From: Simon Davis
Sent: 27 June 2017 10:44
To: Planning.Responses
Subject: FW: Eastergate WTW ref: EG/21/17/PL - Updated drawing confirming tree species to be planted at 1.8m height

Further to submission of DWG 27/307 landscape detail we advise that the information is still lacking in detail. We require that the screening trees indicated, whilst suitable in species choice need to be detailed in plan form showing (ideally Latin name – so as to be clear of species being proposed) and in addition quantity proposed and the size of these at time of planting. It is assumed that as they are being proposed as screening trees then they should be at least as standards or feathered tree size.

- NOTES:-
- 1. TREE PLANTING
MINIMUM HEIGHT OF NEW TREES TO BE 18m WITH TREE STAKES
 - 2. FENCING PANELS TO MATCH EXISTING

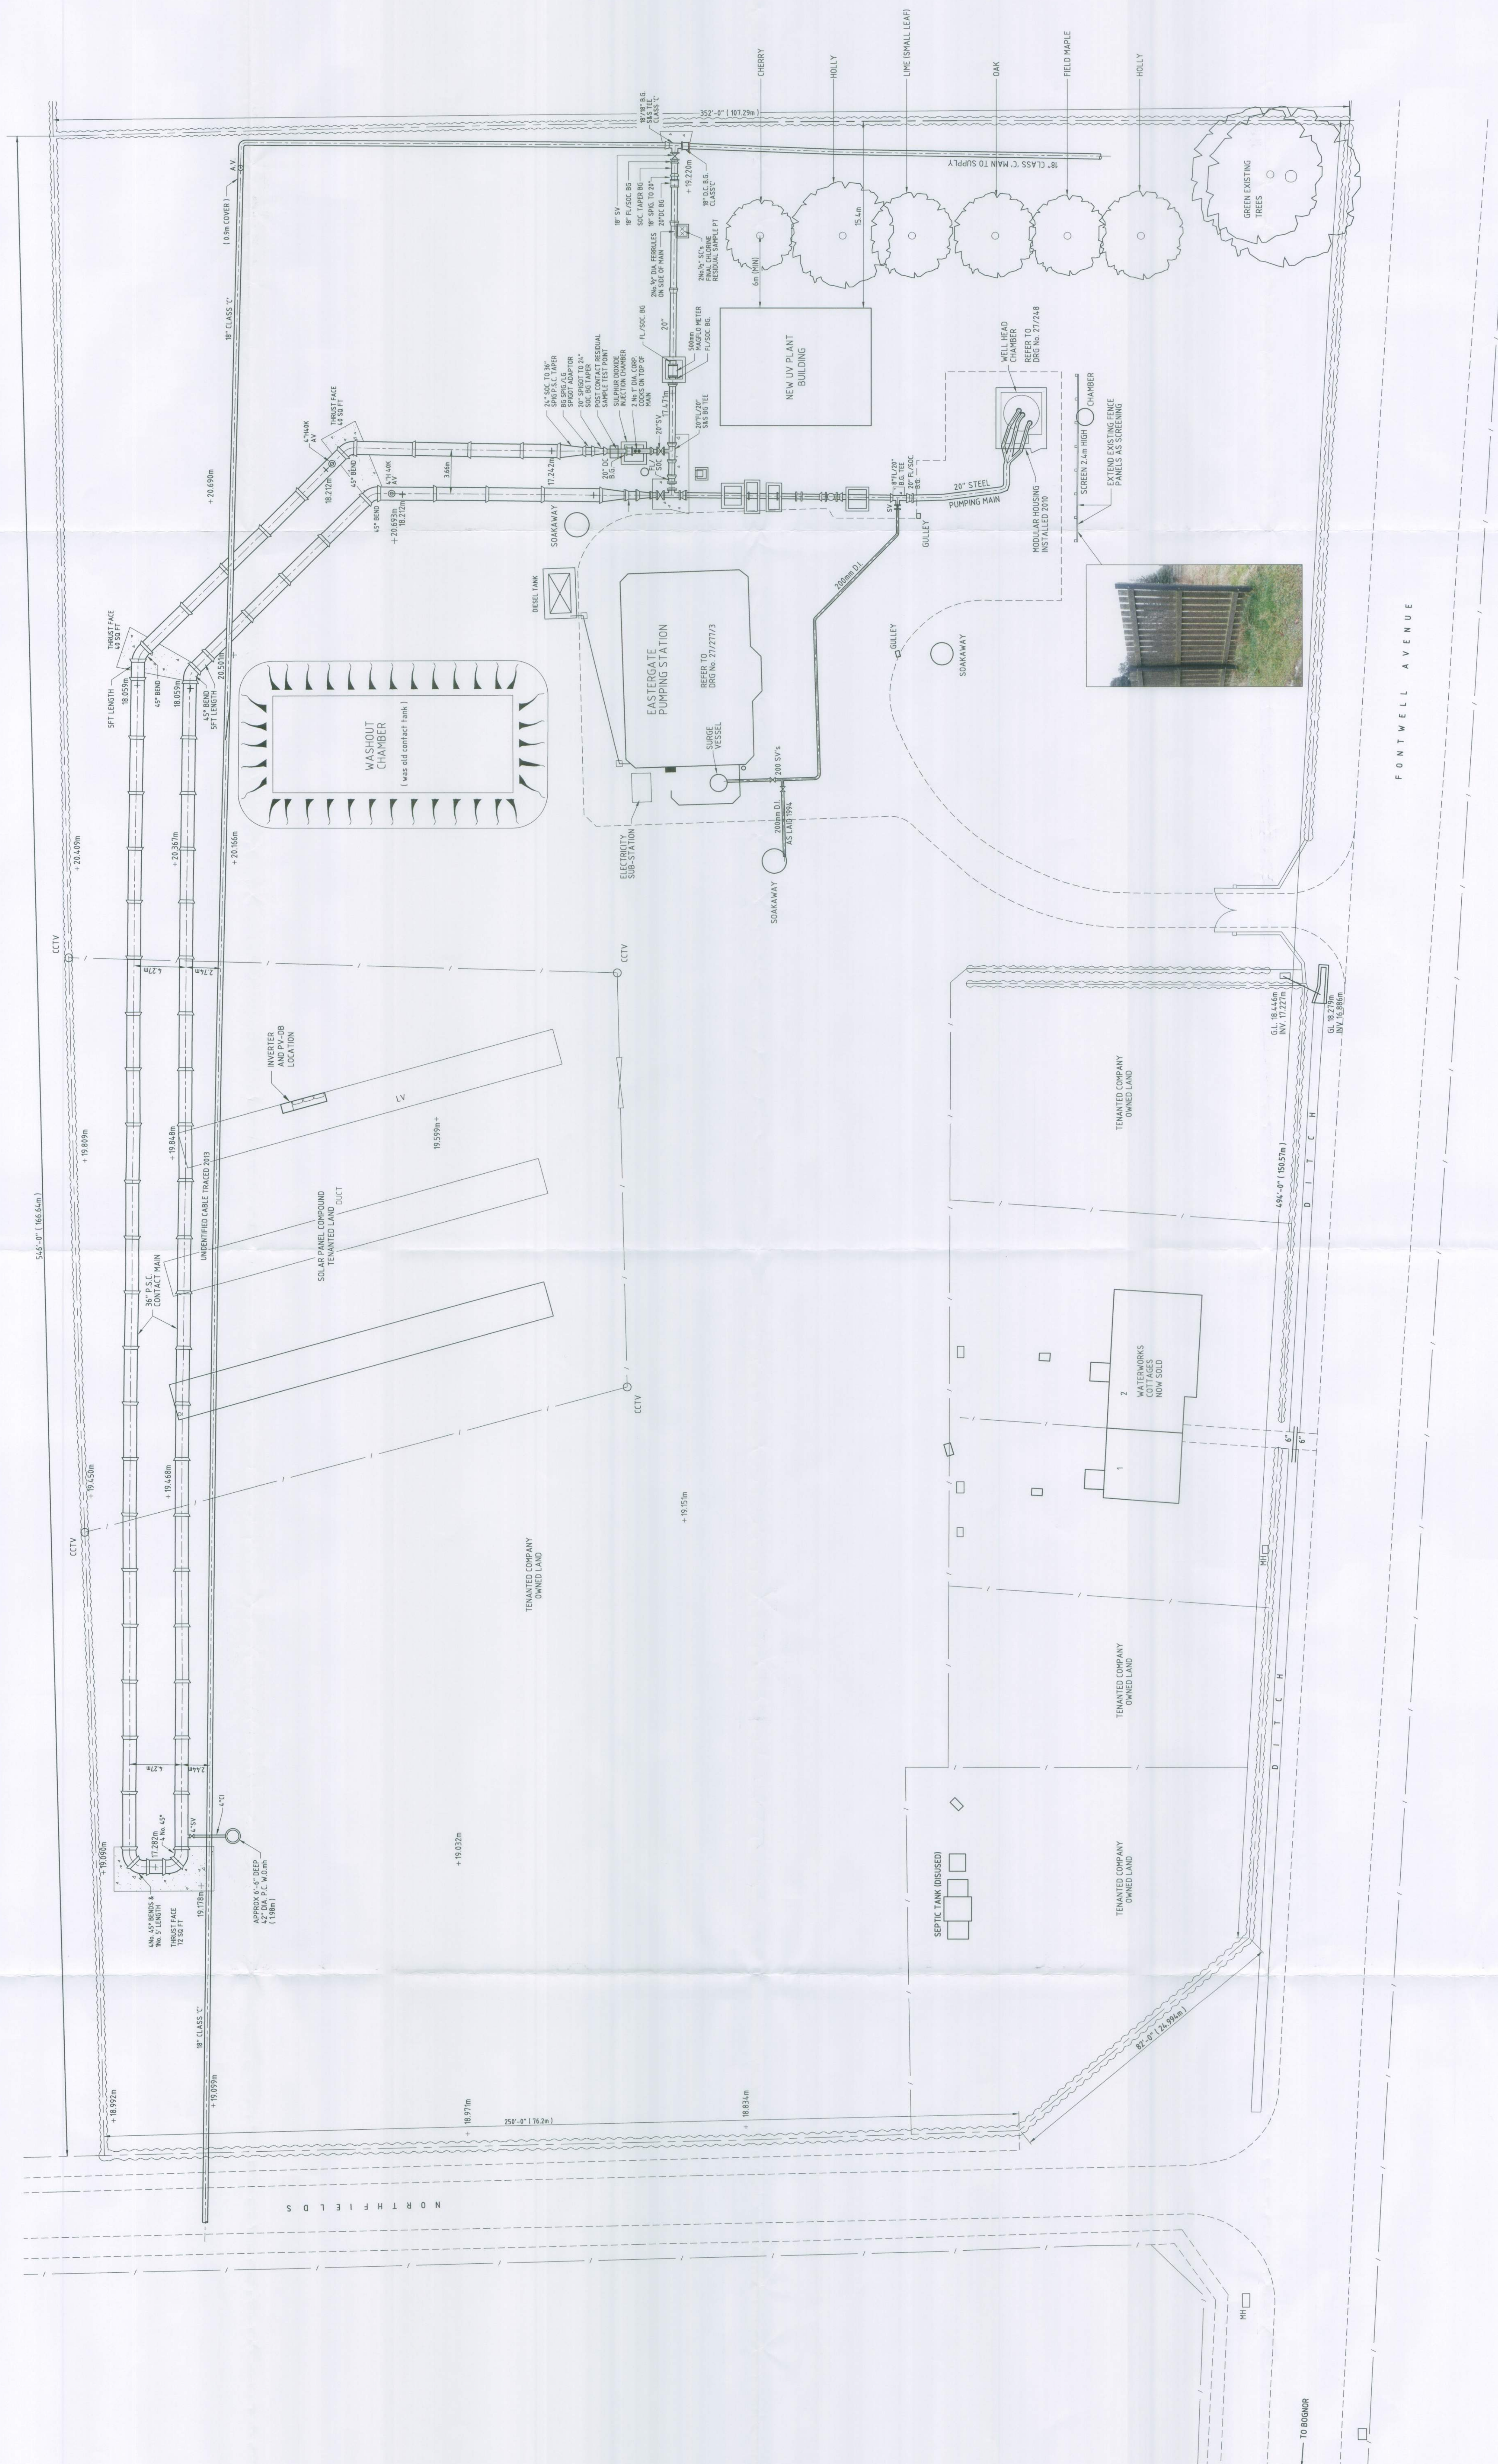
We recommend that this information should be submitted for approval.

I can confirm that I would now recommend to planning no objection to the proposals submitted and that the drawing now includes the previously lacking information.

Further to our conversation this morning, please find attached the annotated drawing showing the latin names of the trees to be planted.

Native provenance (SE England) trees have been purchased from Mill Farm Trees, near Winchester. The invoices on page 2 of the attachment confirm the trees purchased are 175-200cm in height. The note on the bottom right of the drawing confirms that the trees are a minimum height of 1.8m.
